AHA! Affordable Housing In Arundel
"Seeking to Preserve Arundel"

Re: 46 retirement Flats at Blastreat and Greenhurst , 14 Fitzalan Rd Arundel.

The alleged breaches of National and Local Validation Requirements and good architectural drafting practice include but are not limited to the following:

Block Plan
Scale 1:500

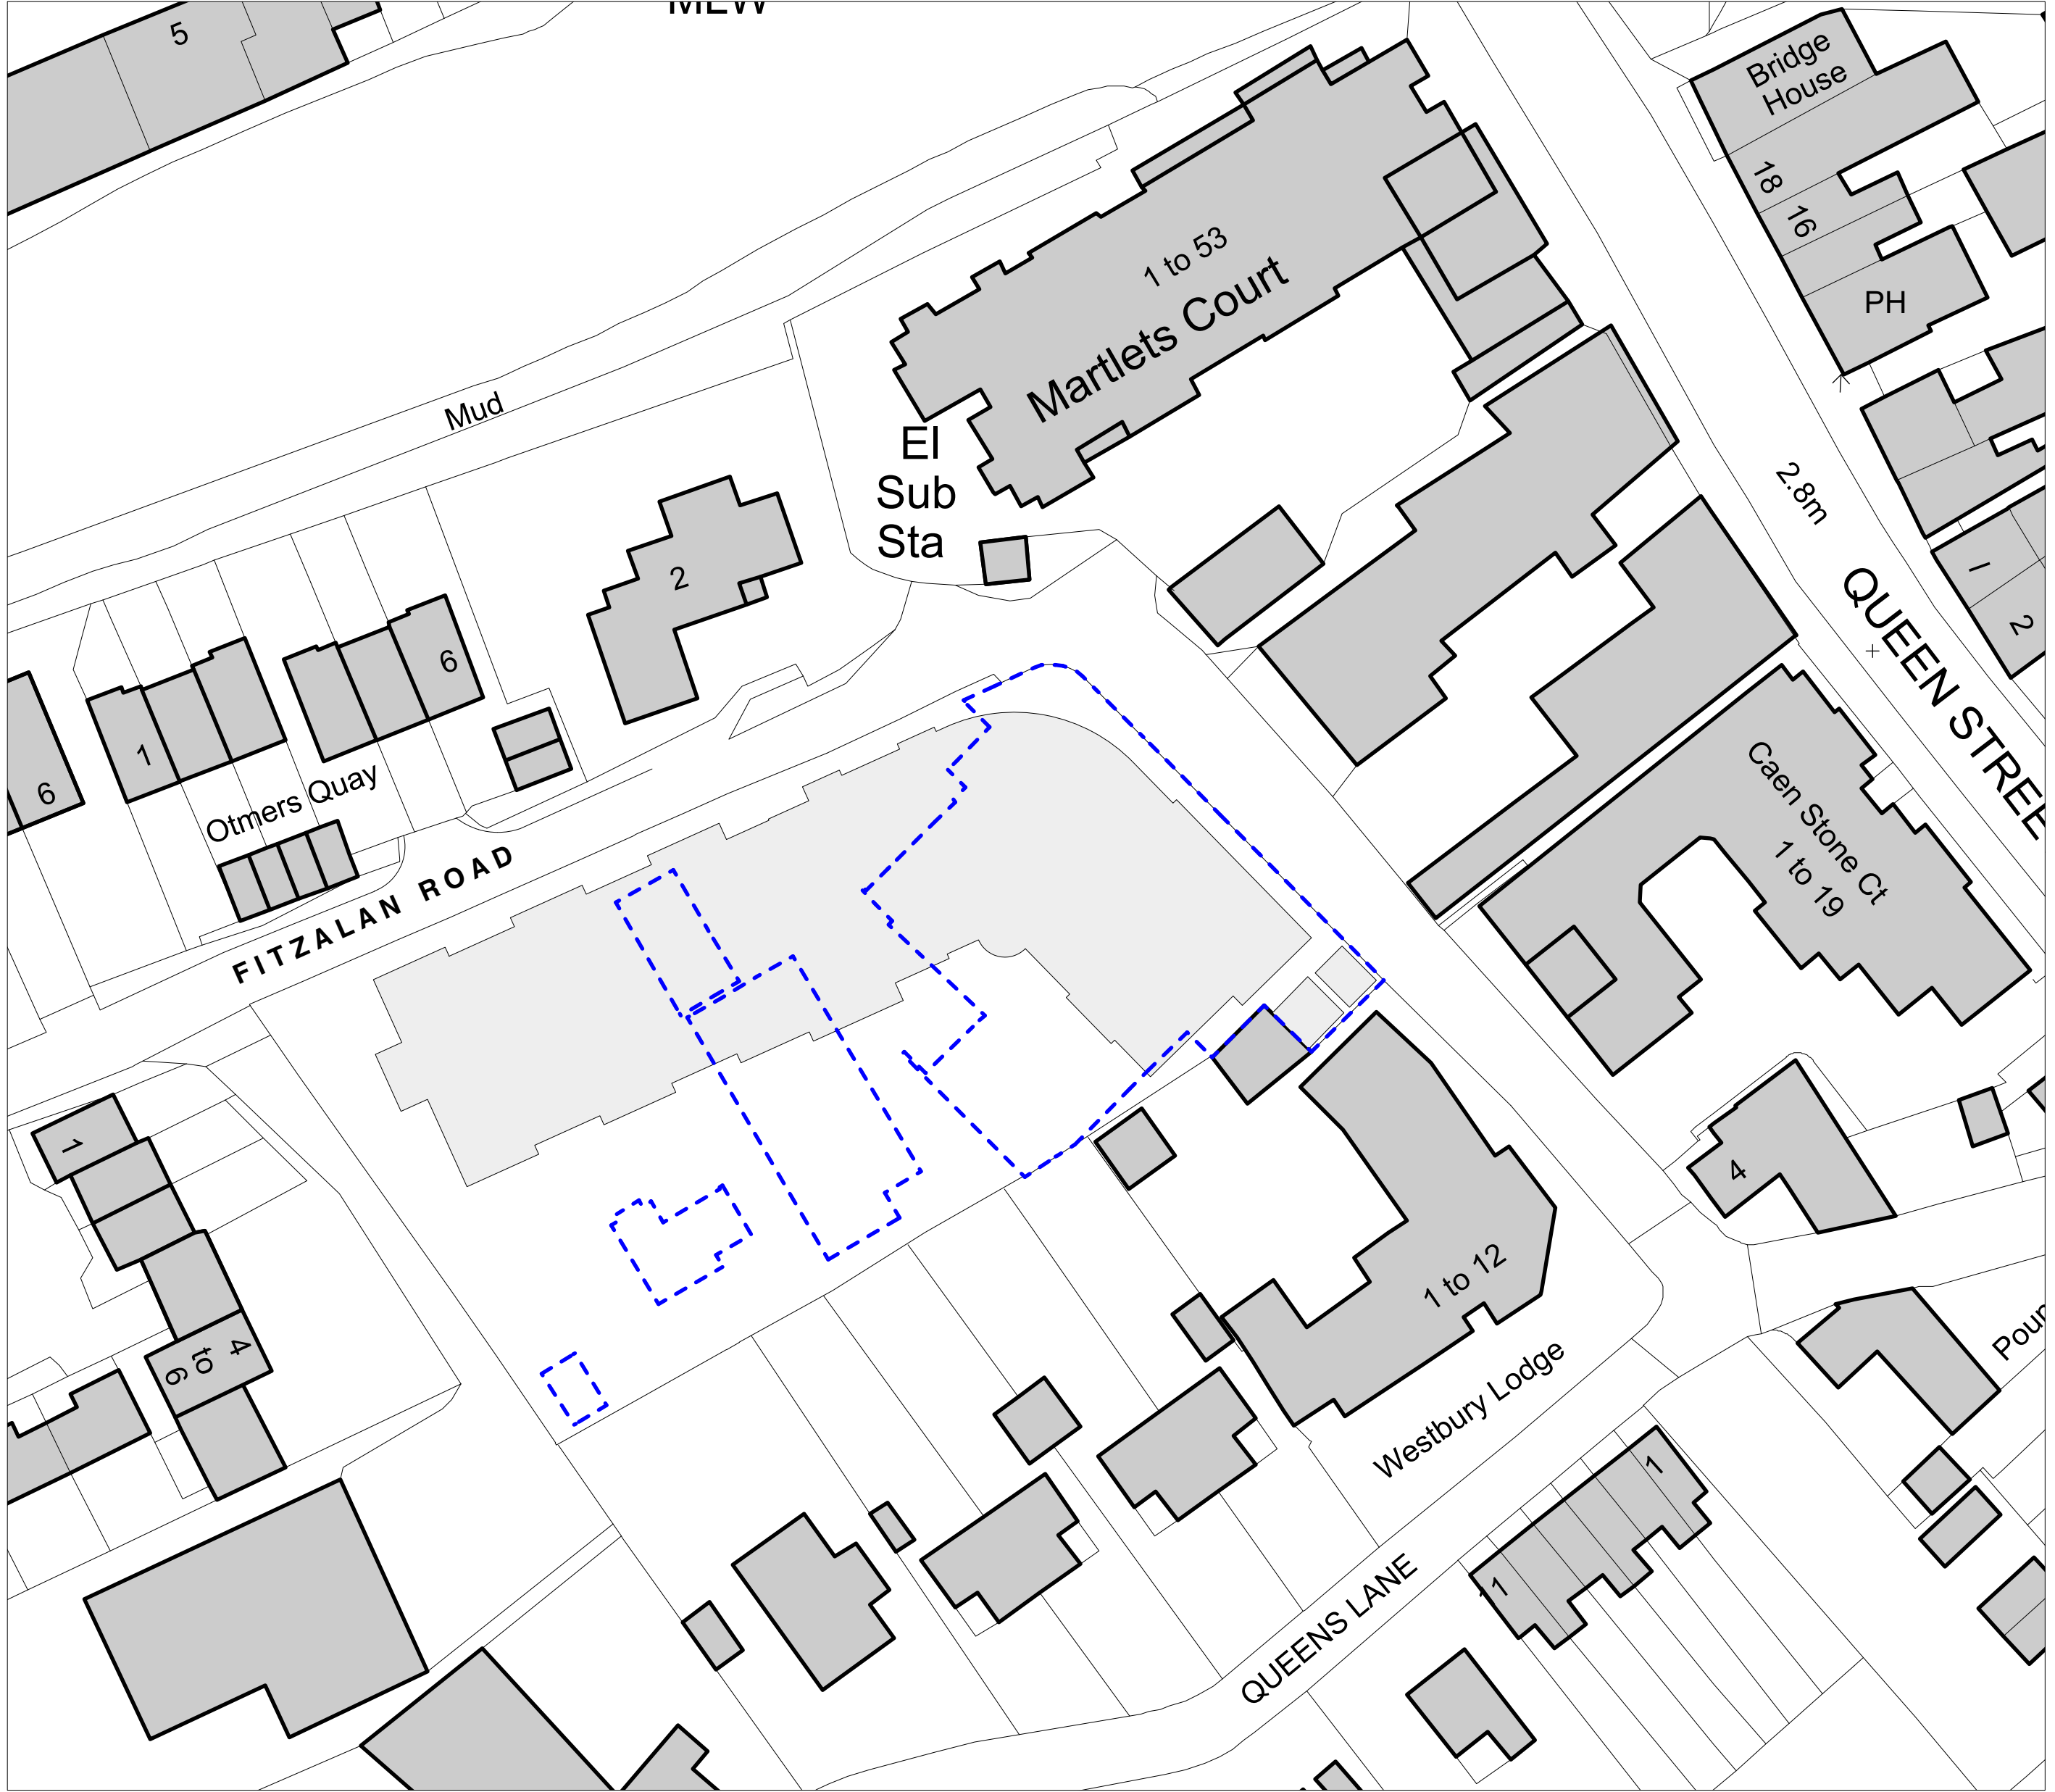
23. Please can the applicant confirm precise width of staircase, driveway and verge adjoining the elevation nearest the access. It is currently unclear how each can fit in a width of about 5.8m. **This is potentially very material as it appears that the block cannot fit on the available land or the access road is below standard.**

24. Please can the applicant provide a visibility splay to left / West. **This is potentially very material as they appear below the standard.**
25. The main staircases around the buildings are not shown on the block plan, nor are the raised terraces. Both are structures that form part of the footprint of the building so should be shown in grey. **This is a material drafting error.**

26. We cannot see a turning head suitable for emergency service vehicles. **This is potentially very material.**
27. Please can the applicant label the grey structures next to Westbury Lodge.

28. Please can the applicant show the car ports on the block plan as distinct from open car parking spaces. Both are coloured the same, giving the incorrect impression of a large open car park when in fact a large percentage of it is covered in a vast car port.

Side Elevation (West)

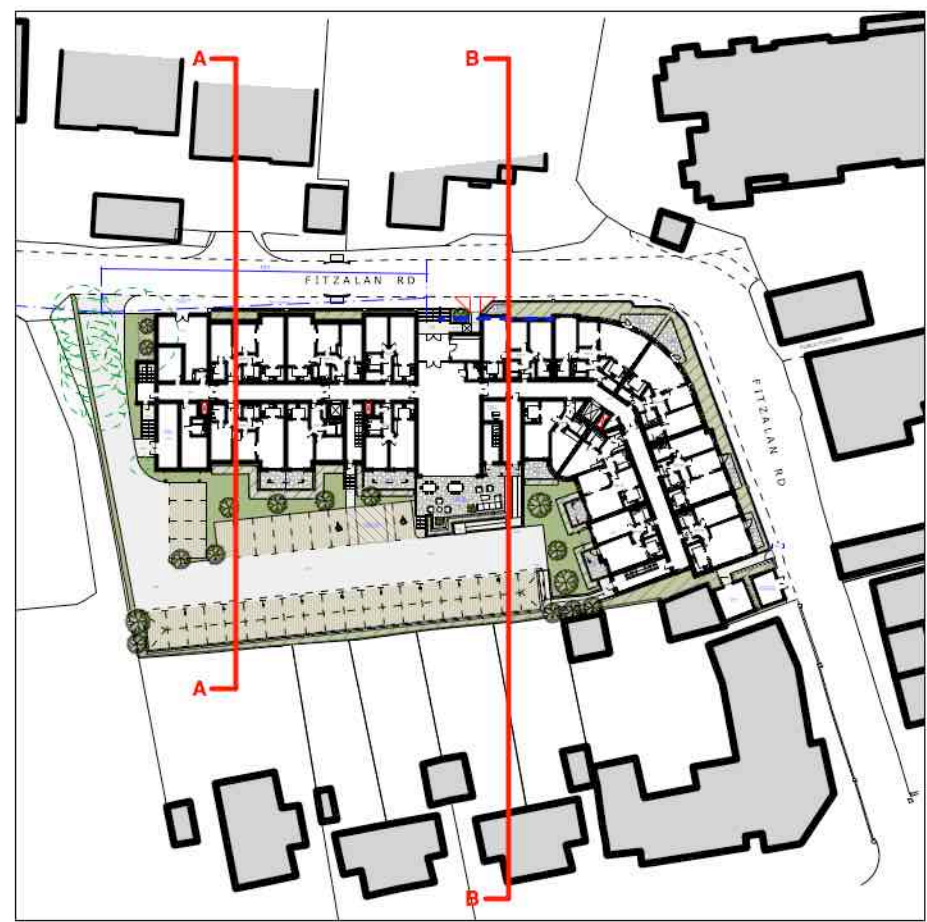
11. The circular part of communal area is not shown and should be. **This is a material error.**

12. The fence and garaging at Otters Quay to the north (or left of the elevation) are not shown and should be. This gives a false impression of space around the development. Indeed, the architects have misleadingly illustrated a person walking in a “left” direction exacerbating this false representation. In reality, that person should be walking into the side of a garage block situated circa 9m from the face of the proposed building. It is important to show these garages because it shows how cramped and narrow the proposed building is within the street scene.

13. The most southerly projecting atriums/staircase to right next to the sub-station is not shown. Again this is important because it's the closest part of the building to Westbury Lodge. **This is a material error.**

14. Trees are shown at circa 6m in height with a 3m equally balanced crown (visible from each elevation). These trees can't fit in a 2m verge and should be removed from the plans which in turn will demonstrate that there is not in fact enough space for the proposed landscaping and the detrimental impact on the conservation area will be increased.

15. The second floor balconies are 25m from the rear gardens of the houses in Queens Lane and a person on the balcony would stand some 9m above the height of a person standing in those gardens. The complete loss of privacy from 12 sets of doors, 12 windows and 6 balconies and a substantive communal balcony would be shockingly severe and should be clearly shown. It is not.

16. The car port is shown as being situated around 1.8m south of the part of the proposed building nearest Westbury Lodge described as the “reveal” in the architect's drawings. This is completely wrong. The car ports are set much farther north, closer to the main part of the proposed building. If the plan were shown correctly, which they are not, it would demonstrate the cramped nature of the car park,

Reveal Elevation (South West)
Fronting Fitzalan Road

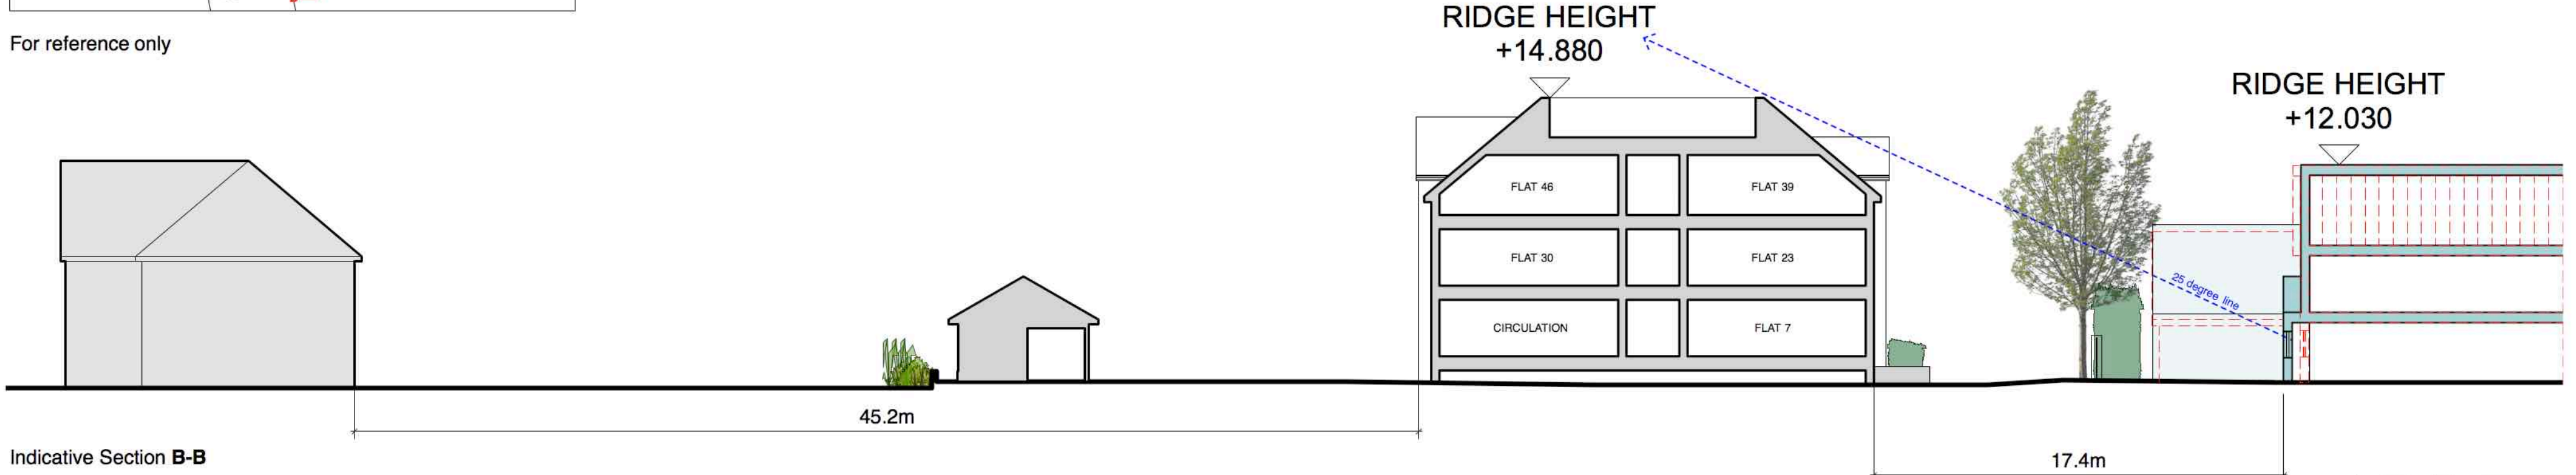
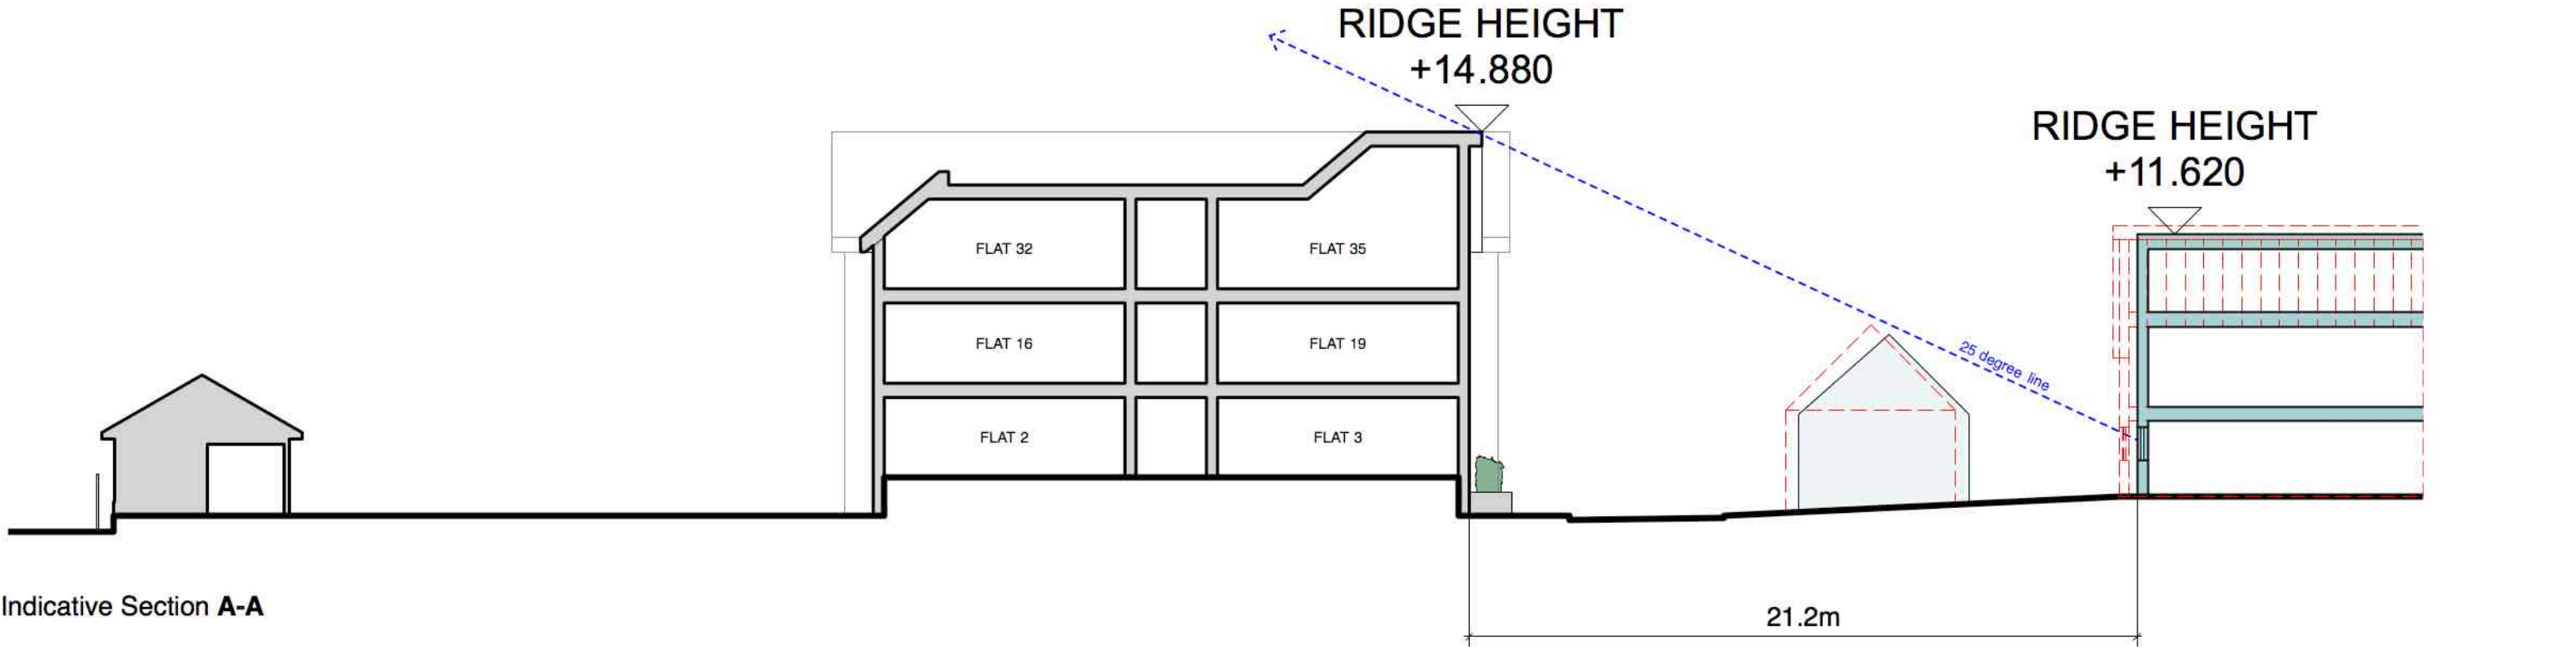
18. It is important to note that none of the plans clearly show the relationship between the balconies and windows of the most southerly part of the proposed block adjoining Westbury Lodge and the rear gardens of Queens Lane. This section of the building is described as the “Reveal Elevation” on the applicant’s drawings. It shows 3 balconies and 7 windows facing at 45 degrees towards the rear gardens of Queens Lane. This means a person standing on the proposed first floor balconies could see into the rear gardens only around 6m away. This is impossible to determine on any of the plans and is such a gross breach of overlooking and privacy that a clear plan showing the overlooking must be provided.

20. The reveal elevation also misleadingly shows the electricity sub-station as a detached single story building with greenery all around it. By contrast, it is attached to a garage belonging to Westbury Lodge. **This is material**. This building incorrectly gives the impression of being the side elevation of one of the car ports. It is not and this should be annotated and clarified.
